From: Eve Hearsey
Sent: 09 March 2012 14:16
To: Planning.Responses
Subject: FW: FG/16/12 - Minor Material Amendment - Asda (Country Fayre), Littlehampton Road, Ferring.

From: Graham Evans
Sent: 02 March 2012 09:56
To: Eve Hearsey
Subject: RE: FG/16/12 - Minor Material Amendment - Asda (Country Fayre), Littlehampton Road, Ferring.

Graham Evans
Senior Environmental Health Officer
Arun District Council

Proposed Elevations

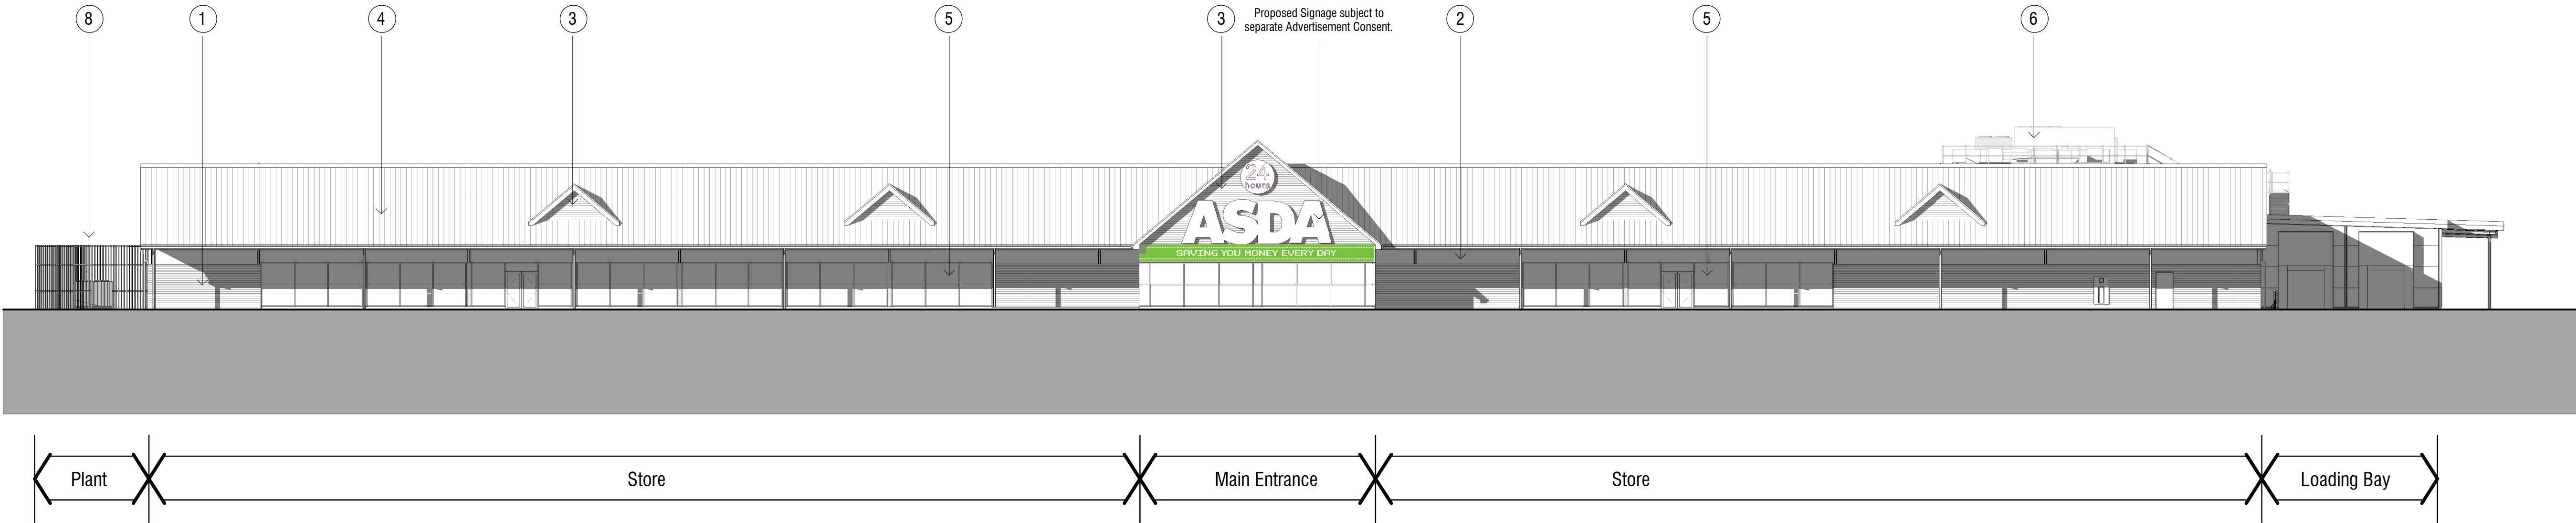
No information is provided in respect of noise produced by the plant, existing background noise levels, or predicted noise levels at nearest sensitive premises, so definitive comment is not possible. It is noted that the scheme does not propose any screening to either plant compound. I did consider the the potential impact of noise from plant and in view of the separation distance to the nearest sensitive residence ("Huntley" @ 100m+?) I did not consider that noise from modern, well maintained plant at this distance was likely to be significant. Noise arising on this site may have a greater impact on future sensitive development in closer proximity and may be a consideration in any application for such development.

You have responded to the above thank you, but I have been asked to check that you have considered both the air conditioning units on the roof together with the refrigeration plant on the east side of the supermarket and the pump room etc. on the west side of the building, particularly with regard to the surrounding residential properties.
